**Report of the meeting of the Development Control Post-Committee Site
Inspection Panel held on 15-05-2018**

REF NO: EP/7/18/PL

LOCATION: Land rear of Beechlands Cottages
Beechlands Close
EAST PRESTON

PROPOSAL: Demolition of existing buildings and erection of 2 no. dwellings with associated car
ports/parking, alterations to existing access and relocation of staircase to flats -
Amendment to EP/138/17/PL

DATE	SCALE	DRAWN BY	CHECKED BY
Nov 2017	1:100 @ A3	GM	
JOB NO.	DRAWING NO.	REVISION	
17009	2.03	A

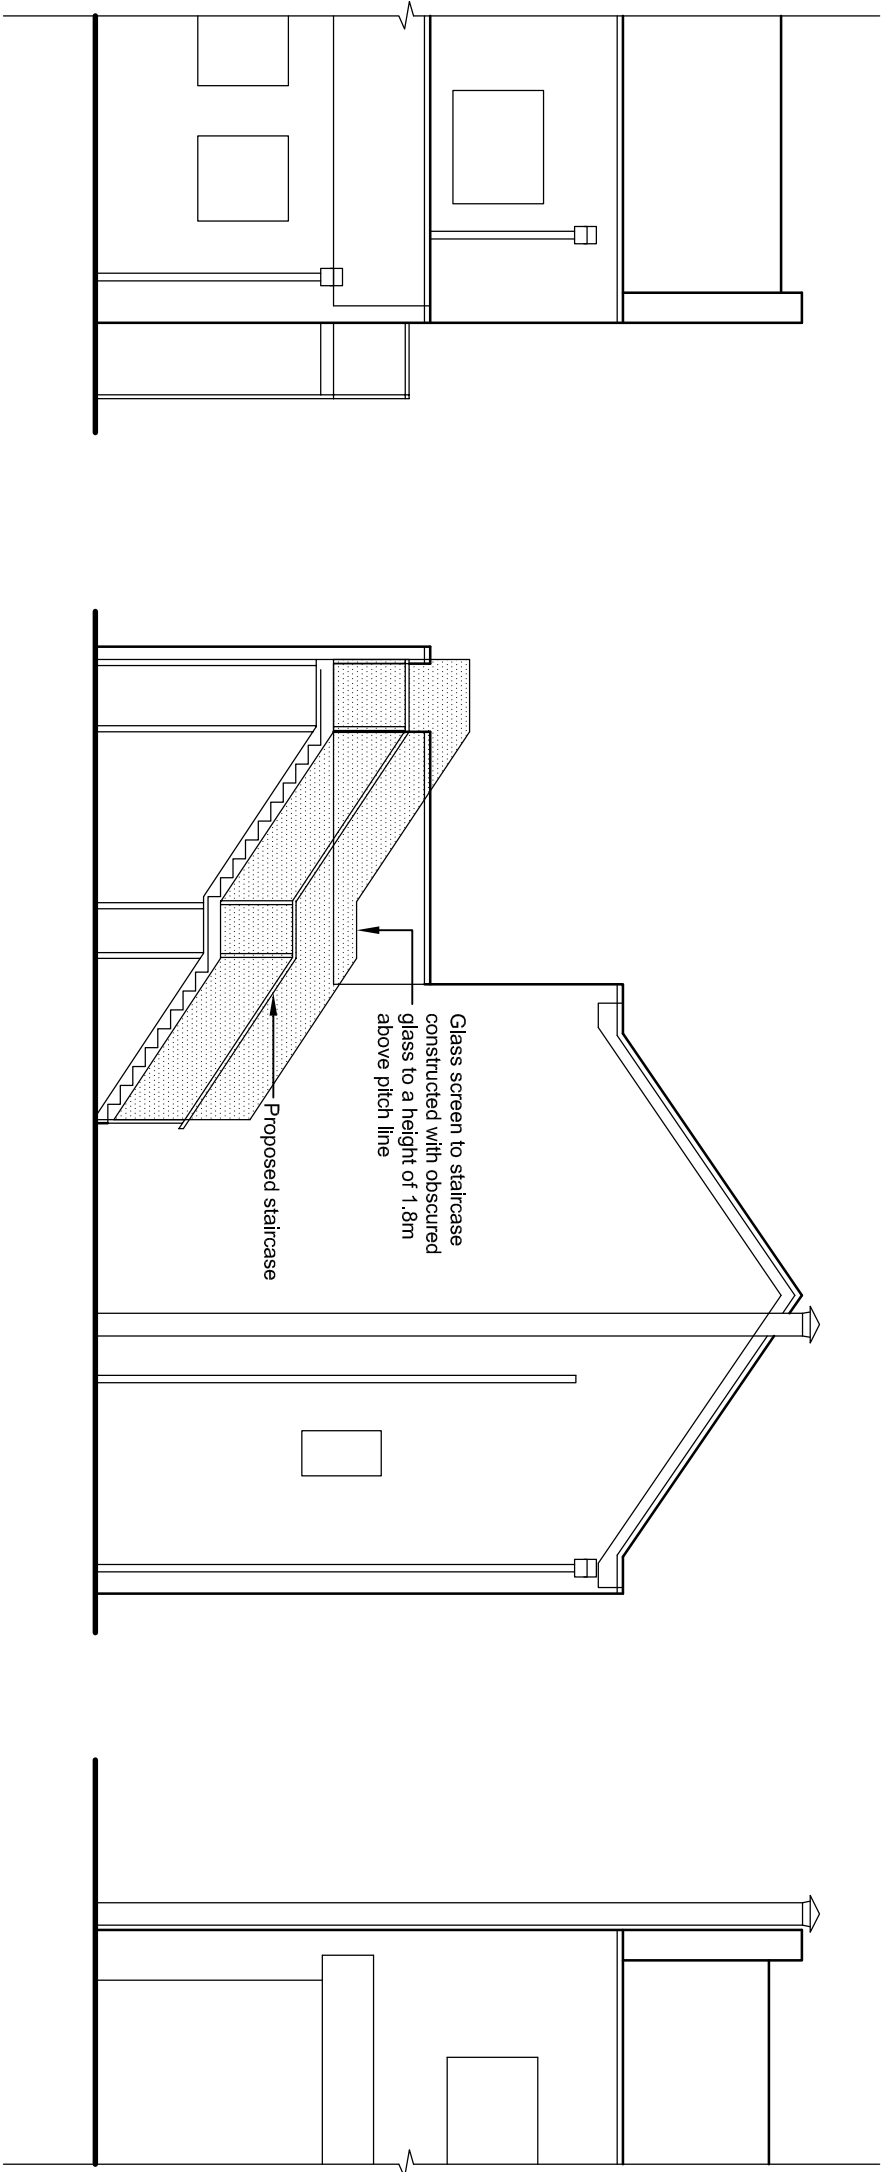
- The distance for the young family in flat 143 to the new proposed fire escape is unaltered at 34 metres and the landlord's most recent tenants adjacent to them in flat number 139 have a child. If there is a fire in either of the 2 Northern end flats over the shops, numbers 129 (over fish & chip shop) & 133, have no viable safe means of escape for the residents if the fire escape were to be relocated as per the plan. In these circumstances people including young children would be directed towards the hazard via the various obstructions on the balcony.

- Rear building line is 14.4m from neighbour's building line
- Will be overbearing and result in loss of privacy
- The re-positioning of the metal staircase on the northern end of the existing balcony would be unsightly and only 3.2m from neighbouring property resulting in a loss of privacy.

The rear elevation of the proposed dwellings will be 10m from the rear boundary which is the standard distance for this relationship which precludes any loss of amenity. The relocated staircase, as previously mentioned, is for emergency use only and despite resulting in no additional overlooking than the existing balcony, can be screened as illustrated on the submitted drawings.

The proposal includes relocation of the existing fire escape staircase from the rear of the shops to the northern end of the parade. This would increase the potential for overlooking in this area and potentially increase activity adjacent to the boundary. The relocated staircase, as previously mentioned, is for emergency use only and despite resulting in no additional overlooking than the existing balcony, is indicated on the north elevation plan to be screened with 1.8m high obscured glass. Therefore whilst the staircase would be located adjacent to the northern boundary it would not result in direct overlooking of the neighbouring dwelling.

Site Plan

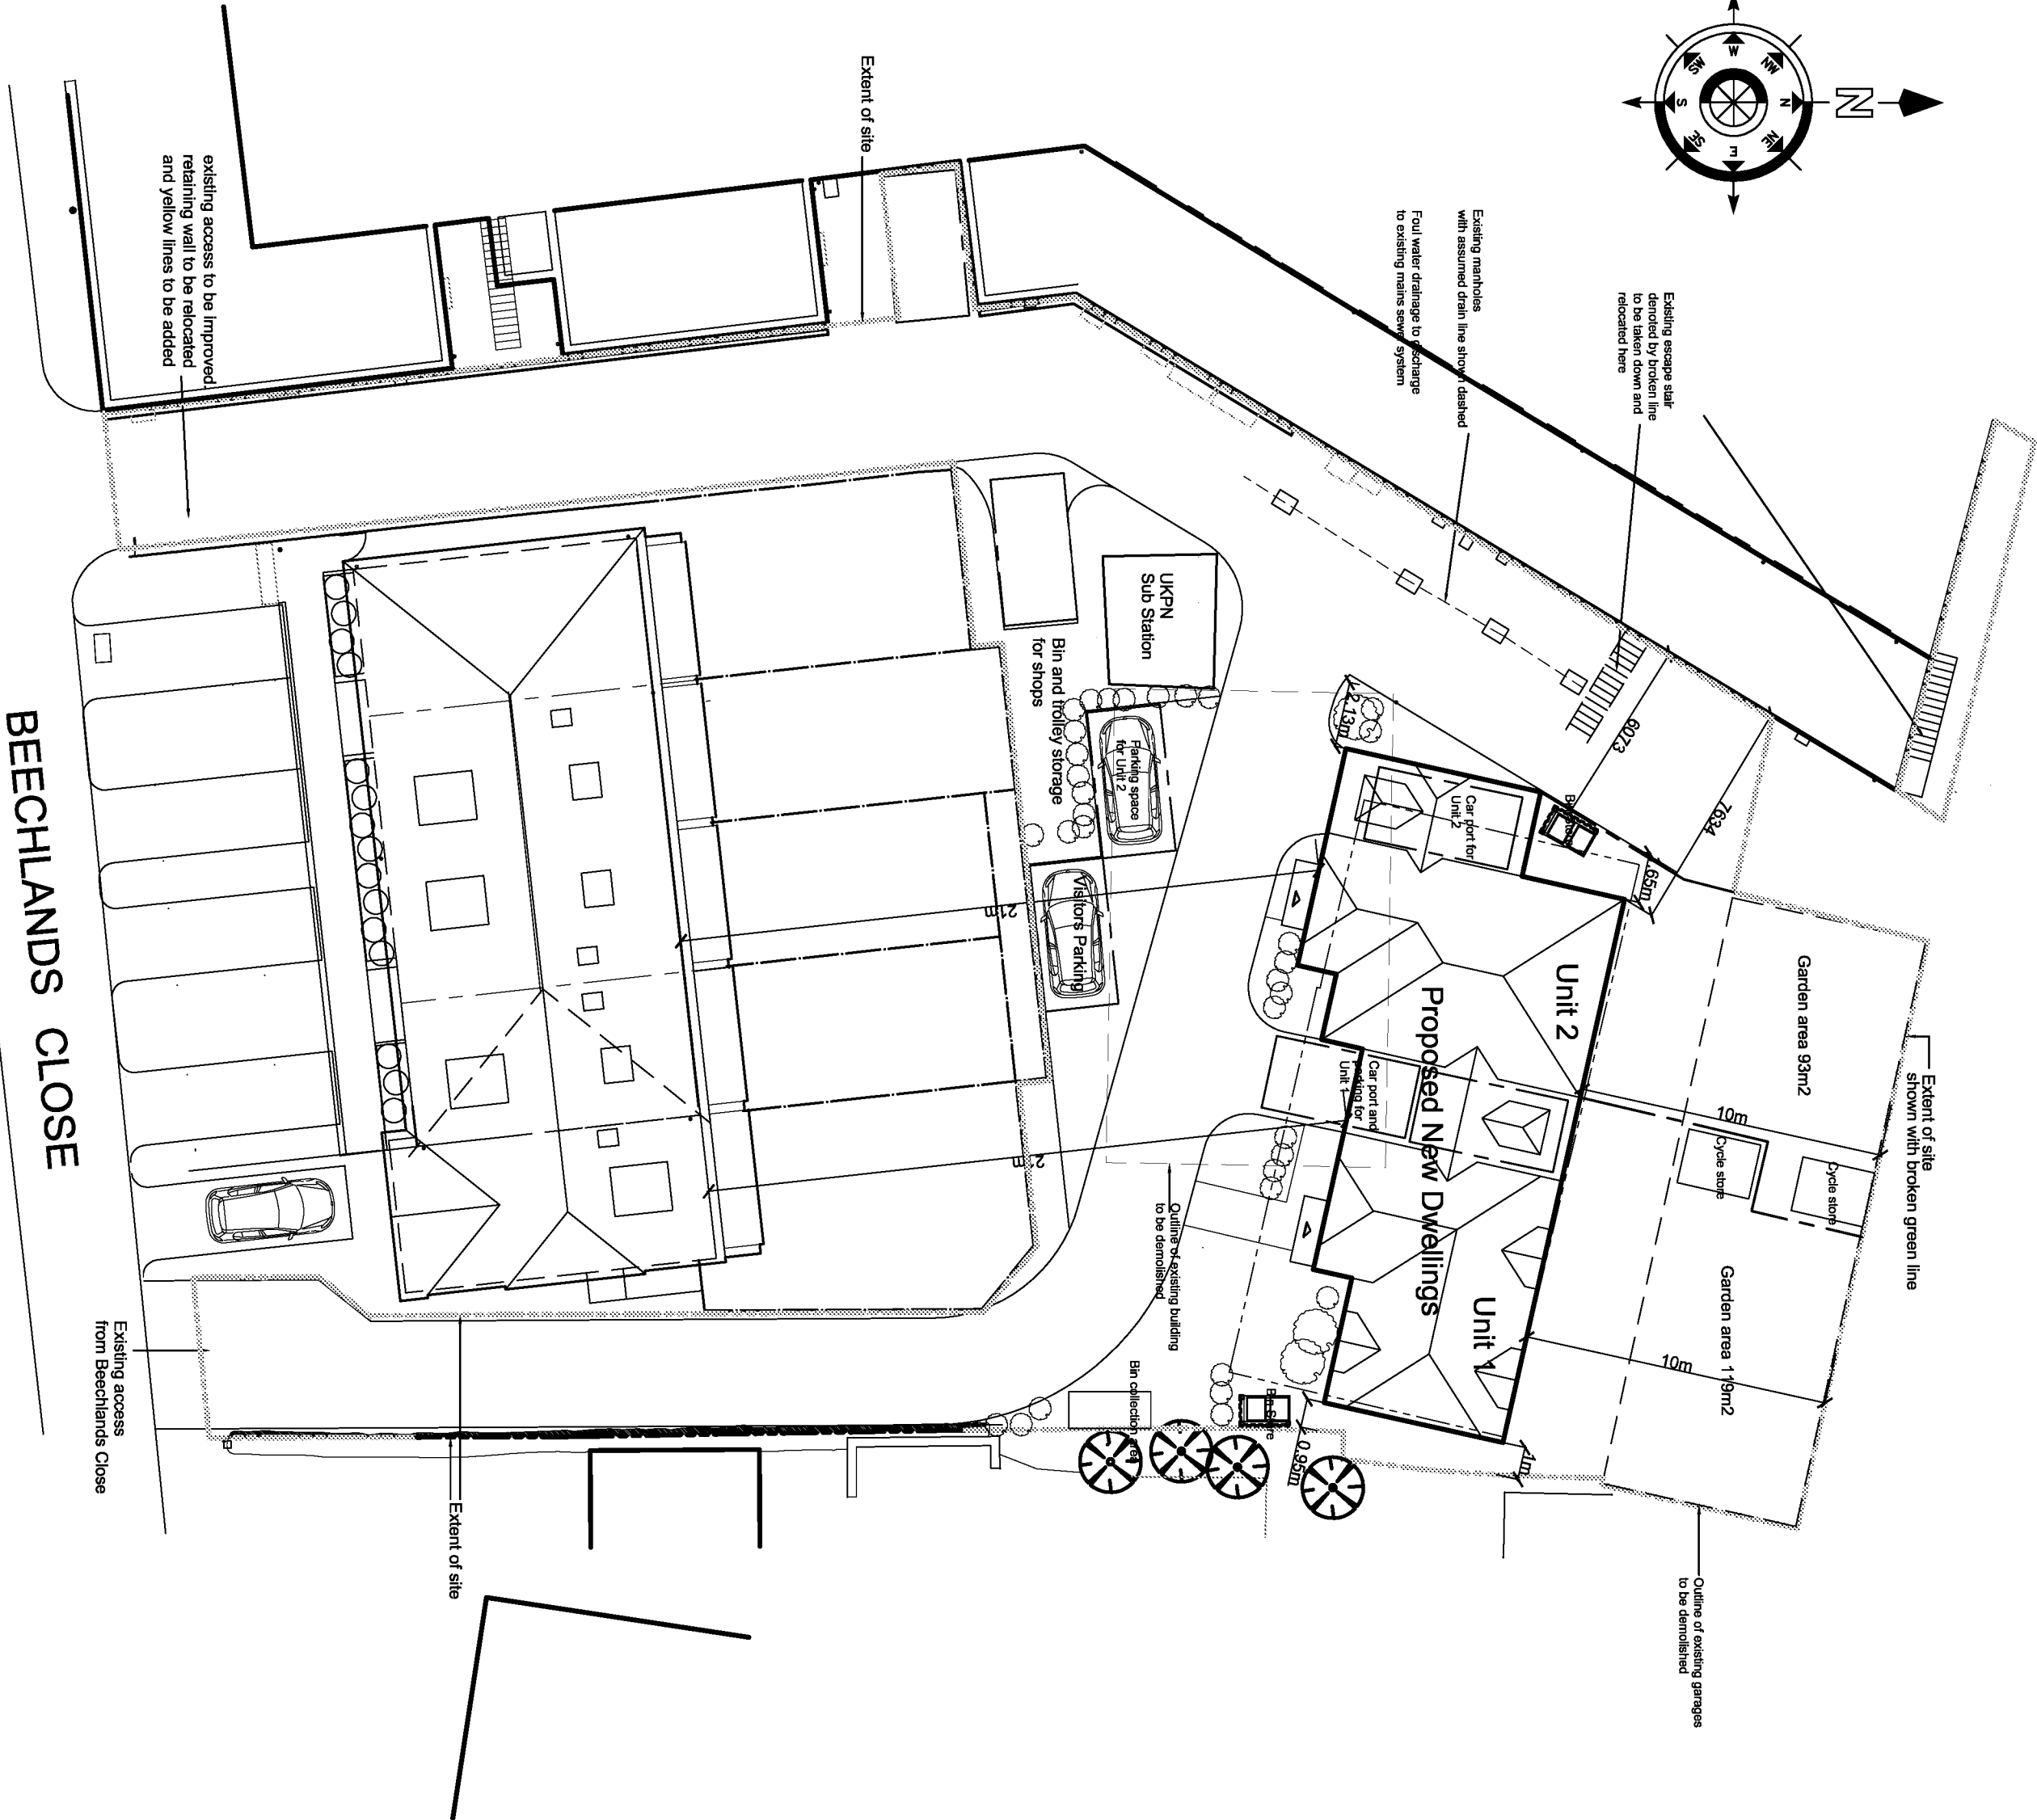
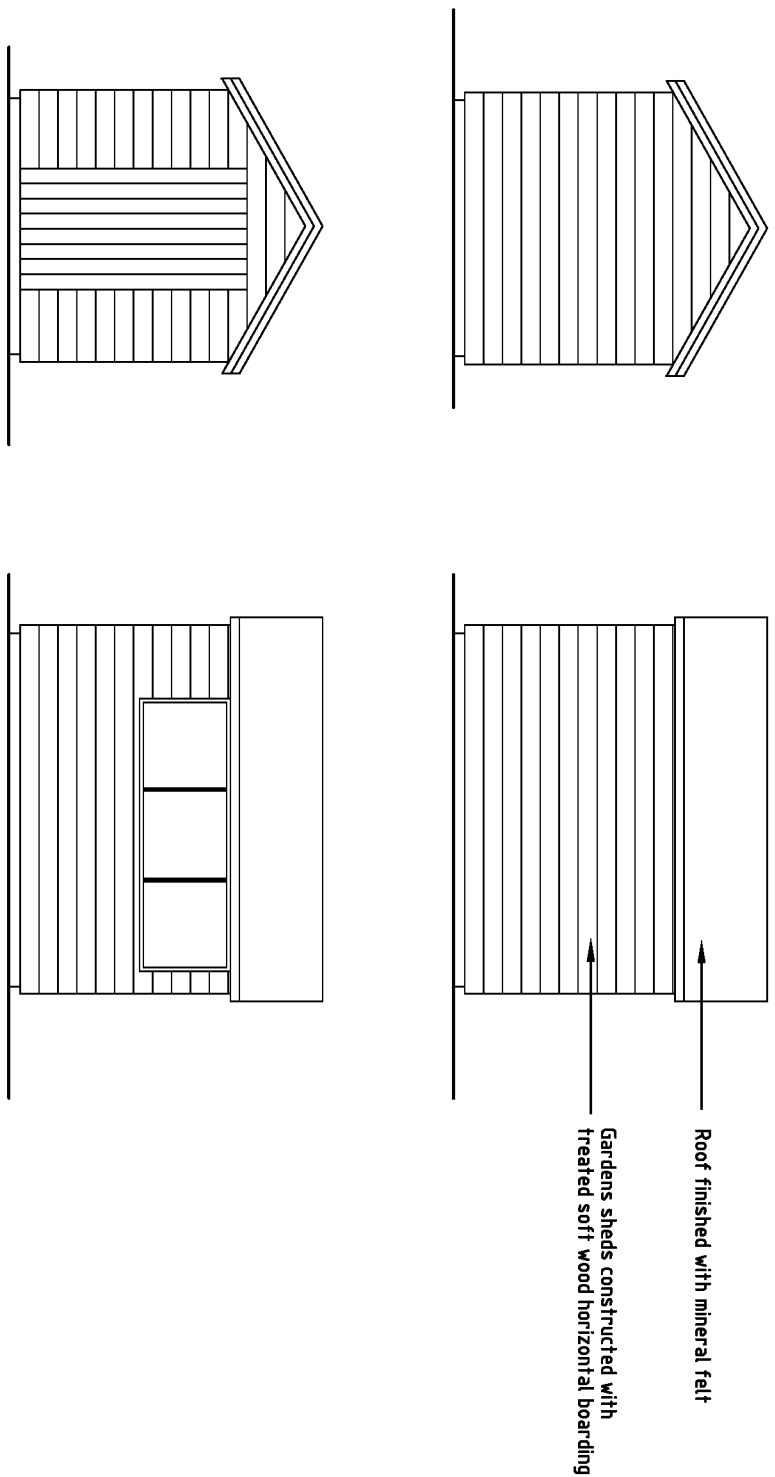
A substitute Proposed Site Plan, Block Plan and Location Plan 2.11 rev E has now been submitted indicating the extent of the footprint of the withdrawn application.

- Where is parking for the substation indicated? Eurosite's tenants are to be refused permission to park at the rear of their premises, but the owners (their landlord) and his tenants disagree, particularly as parking at the front is for customers to the parade of shops and limited to a restriction of 2 hours and not for those tenants attempting to run a business in the parade. Any large delivery vehicles attempting to manoeuvre into this "improved access" would require to ride over the kerbs and pavements ("One Stop" are allowed to do so) due to the restrictions coming in from, and then presumably reversing back into Beechlands Close (blind). Or is there a turning area?

The substitute plan has been referred to in the plans condition.
